# FALCON MEADOWS AT BENT GRASS DRAINAGE CHANNEL

### GRADING & EROSION CONTROL PLANS

#### CDR 21-14

G1.2

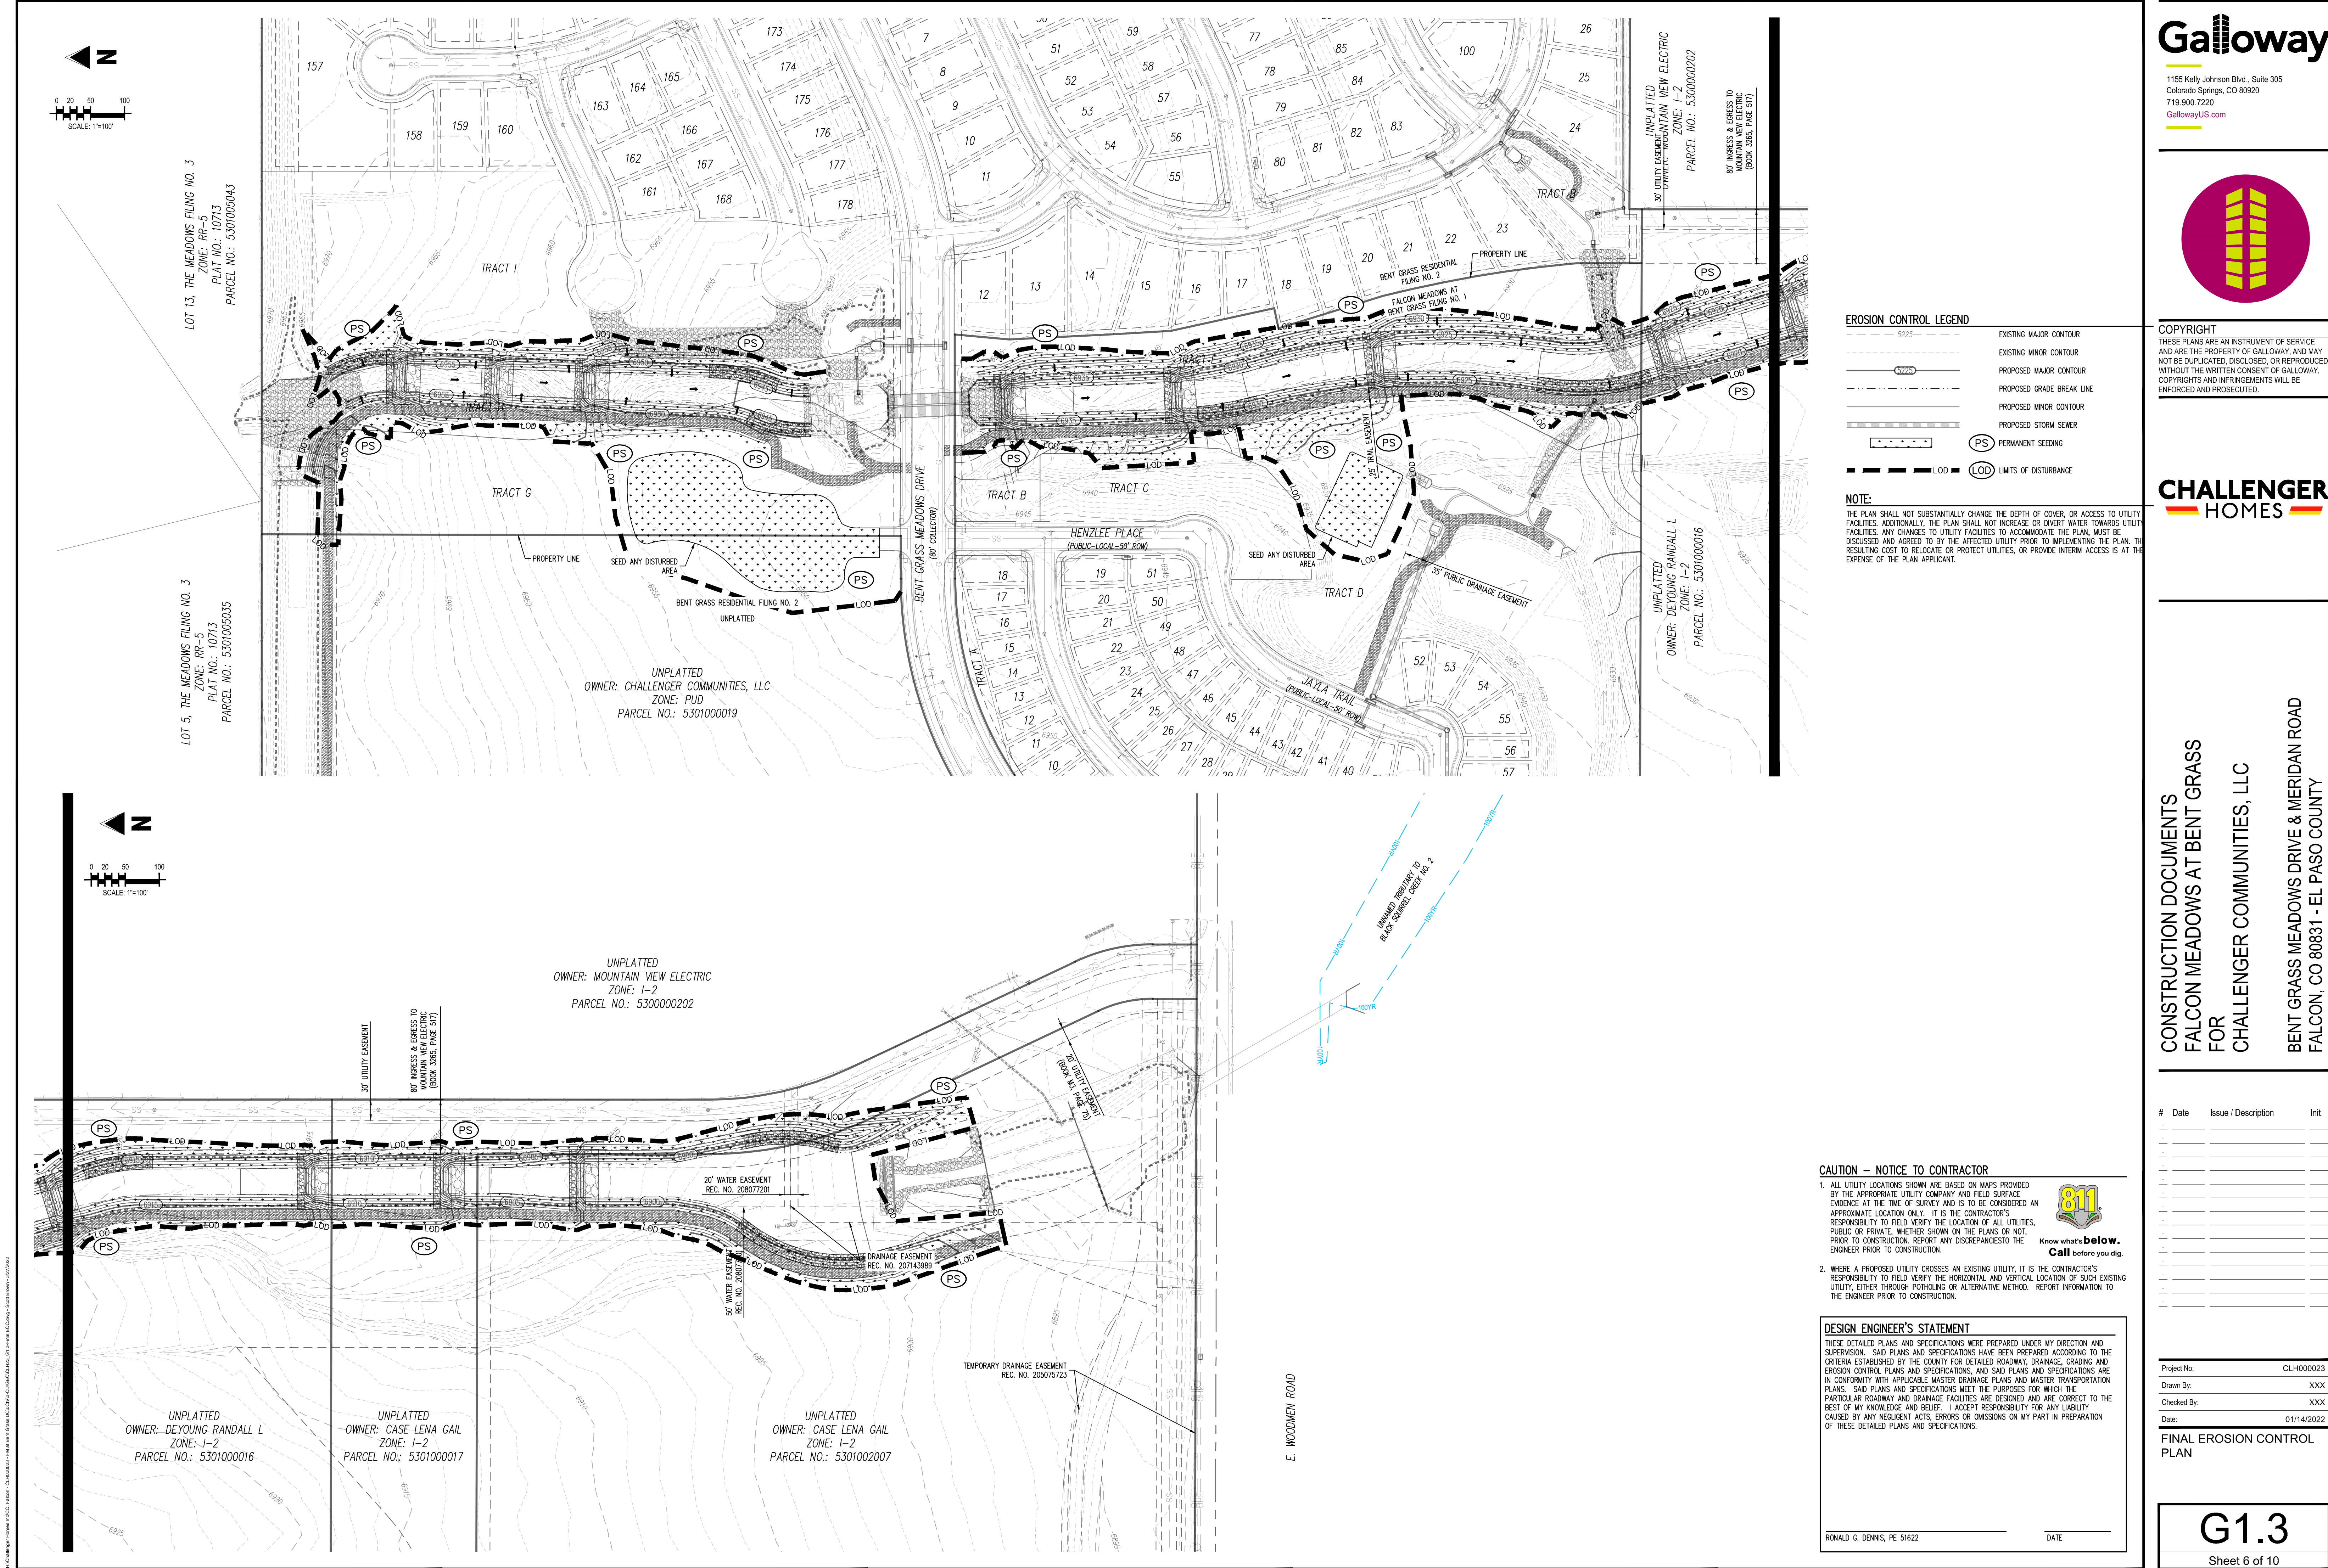
Show access road with turnaround area

PS on top of riprap? Please clarify

Show access road

This berm still needs to be flattened out

Adjust grading

Adjust contours

Provide flow arrows

Add note that this area will need to be filled in prior to development

Label existing maintenance trail

Label existing features/improvements

Label existing road

Label

Label access road grades at all drops

Show and label existing trail/access road

Add note that these areas will need to be filled in prior to development

Connect the access roads
